CHARLOTTE - MECKLENBURG
PLANNING COMMISSION

SUBJECT: Administrative Approval for Petition No. 99-15(c) by University City, LLC.

Project No. 43346
 Sheet RZ-1

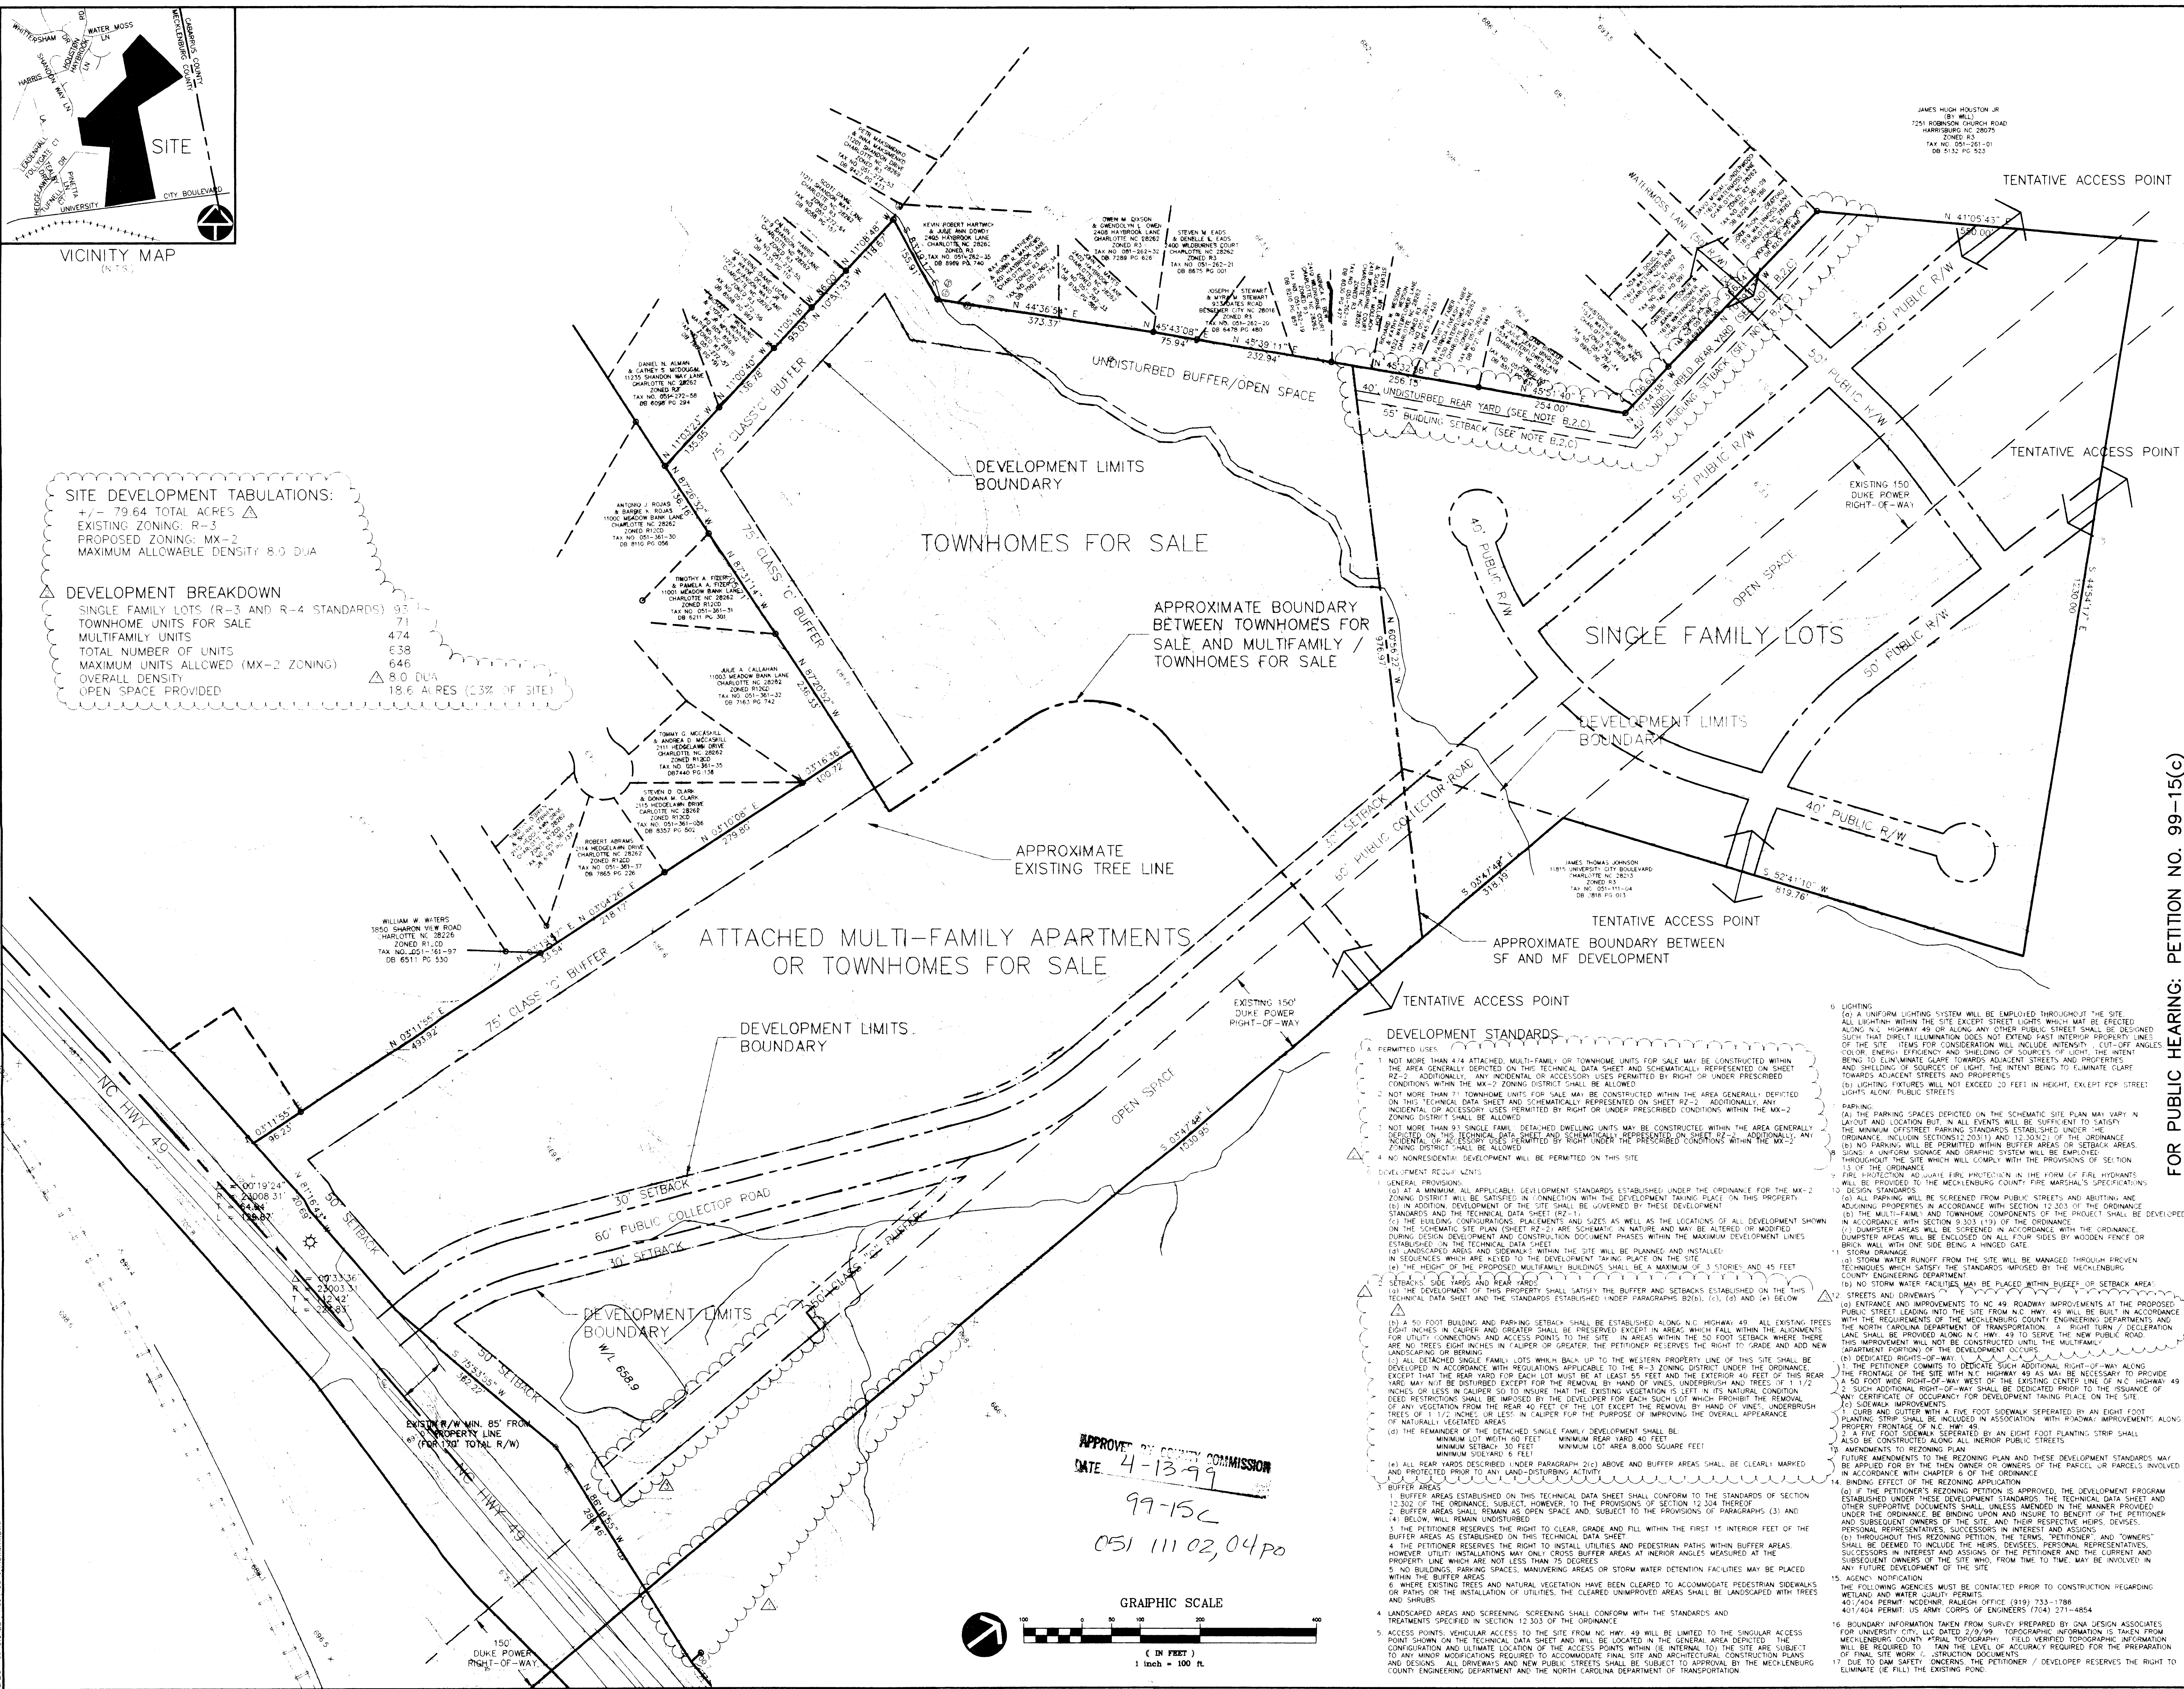
Attached is a copy of the revised plans for the above rezoning petition. Sheet RZ-1 has been revised to reflect a new location for the interior collector roadway within the site. Sheet RZ-2 has been revised to reflect new building layouts. These changes will not increase the number of allowed units from the presently approved plan. Since these changes do not alter the intent of the development and are minor, I am administratively approving this revised plan. Please use this revised plan when evaluating requests for building permits and certificates of occupancy.

Project No. 43346
 Sheet RZ-2

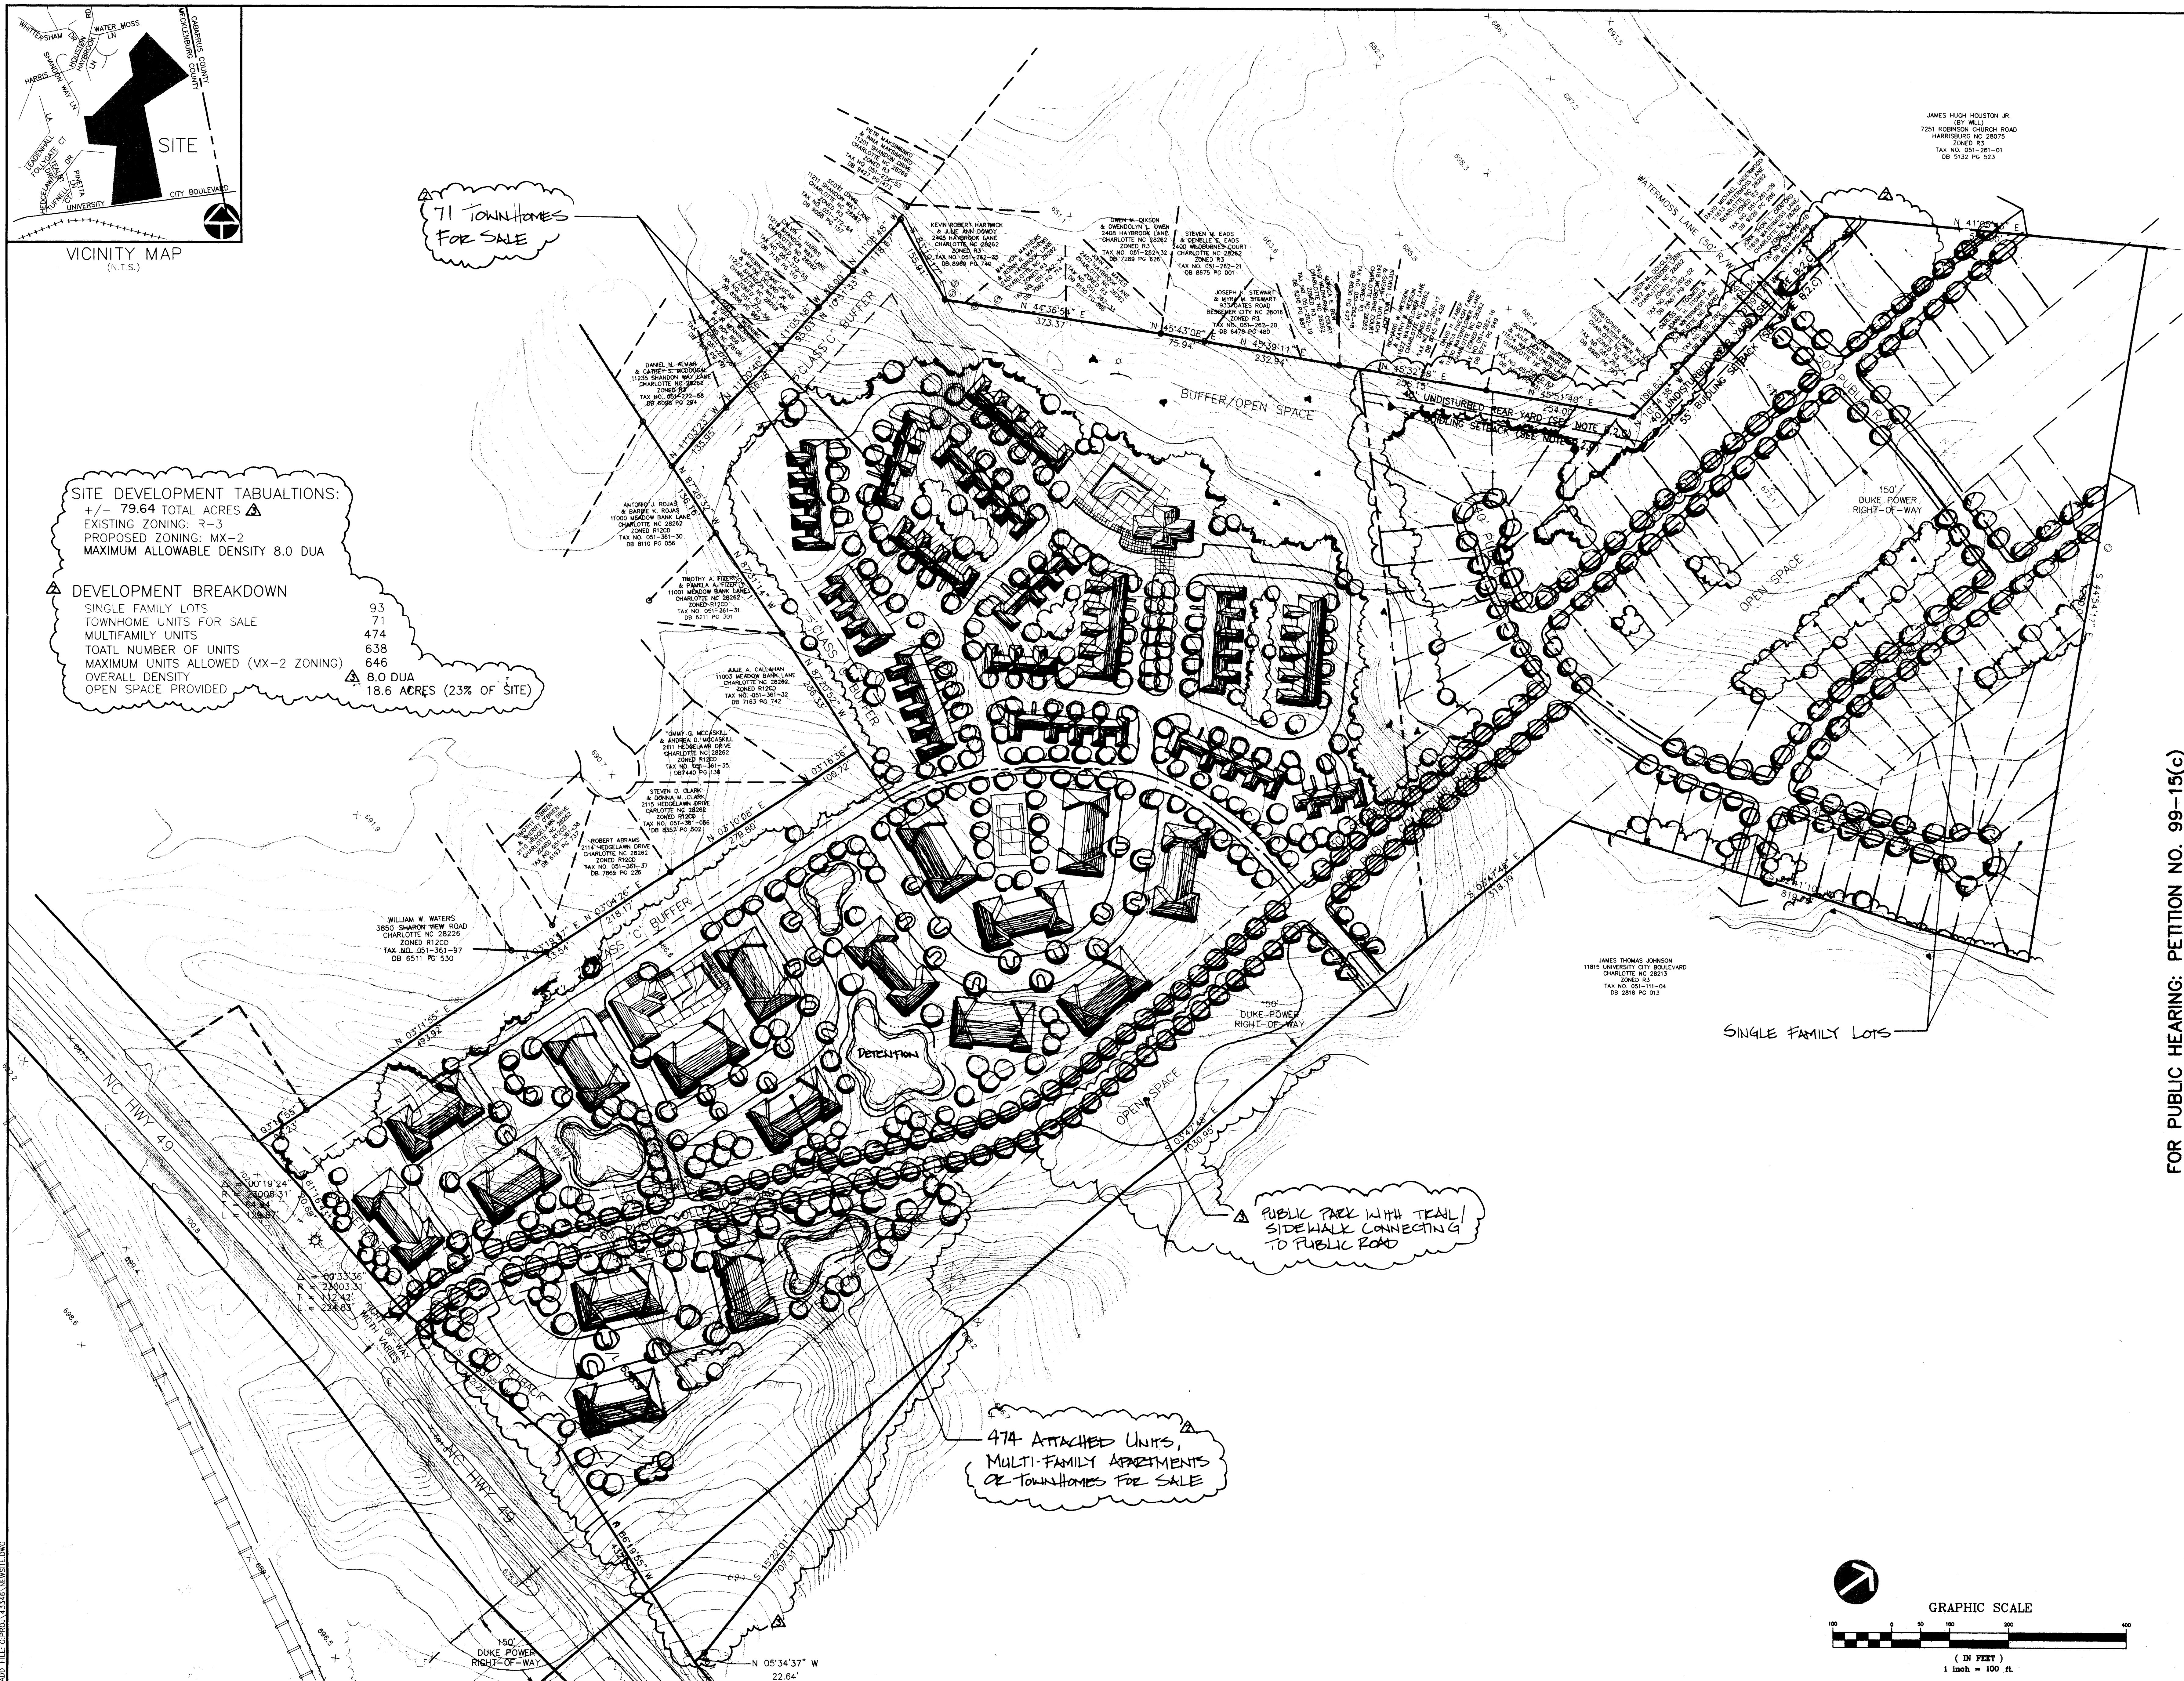
Attached is a copy of the revised plans for the above rezoning petition. The plan has been revised to allow single-family development on parcel "B". This results in a decrease in overall density for the site. Since this change does not alter the intent of the development and is minor, I am administratively approving this revised plan. Please use this revised plan when evaluating requests for building permits and certificates of occupancy.

Attached is a copy of the revised plans for the above rezoning petition. The plan has been revised to revert an administrative approval showing single-family development back to the original approval to allow 75 townhomes. Since this change does not alter the intent of the development and is minor, I am administratively approving this revised plan. Please use this revised plan when evaluating requests for building permits and certificates of occupancy.
